Re Application Reference : 6/2018/1603/HOUSE

Proposed development at 79 Bell Lane, erection of front garage extension

Proposed Front Elevation

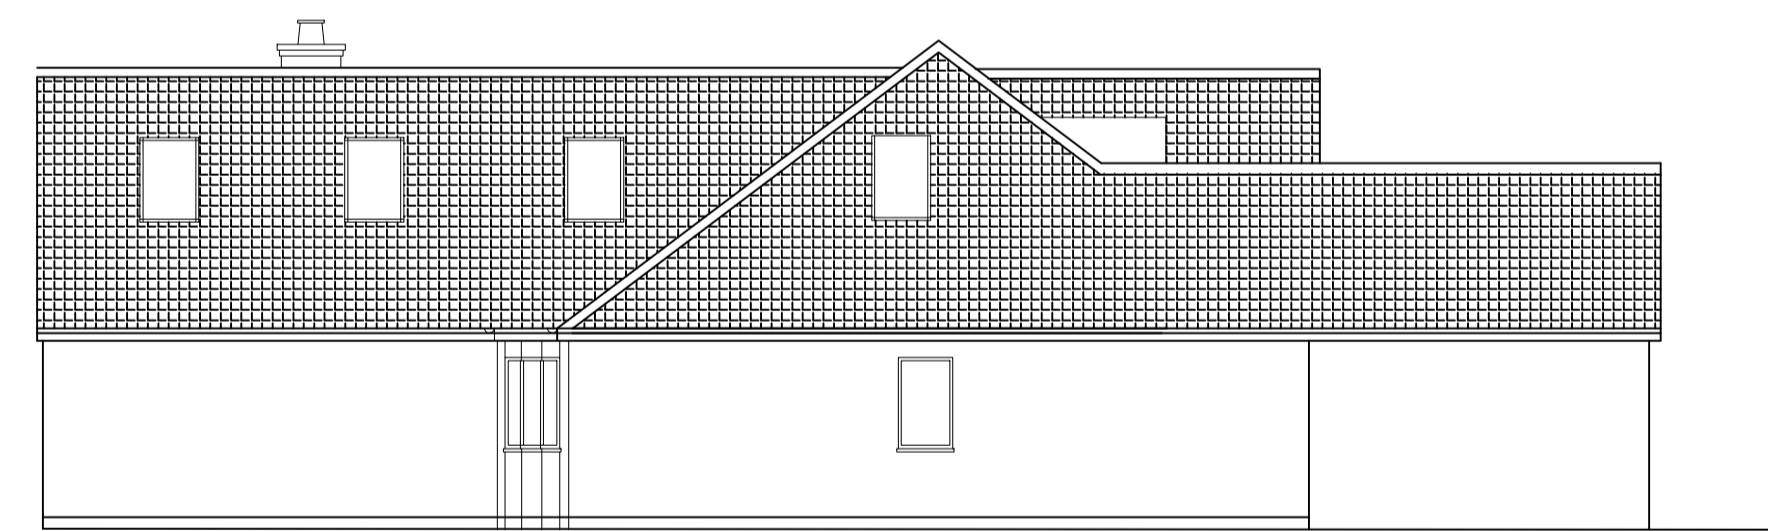
With reference to the above application for a front garage extension of 4.5m, unfortunately we wish to object to this proposal in its current form.

The existing house at No 78 is already several feet forward of our house footprint and if extended an additional 4.5m (no small amount!) would severely impact the light coming in to the front rooms of our house. We would, in fact, be looking out onto the pitch of the roof of the proposed garage extension. An additional 4.5m of pitched roof would also block out our sunlight and with the aspect of the house in relation to the sun, especially during the Autumn/Winter months, would make our rooms very dark indeed.

I have spoken to our neighbour Mr Demetriou to let him know that we would be objecting and the reasons behind it. He was very understanding and suggested that he would speak to his architect to see if it was possible to drop the elevation, thus not causing us such an impact. Obviously if the plans were changed and we were comfortable with the changes we would see no reason to object. This would presumably involve him re-applying for planning permission but please be advised that in its current form we do strongly object to the application for the above reasons.
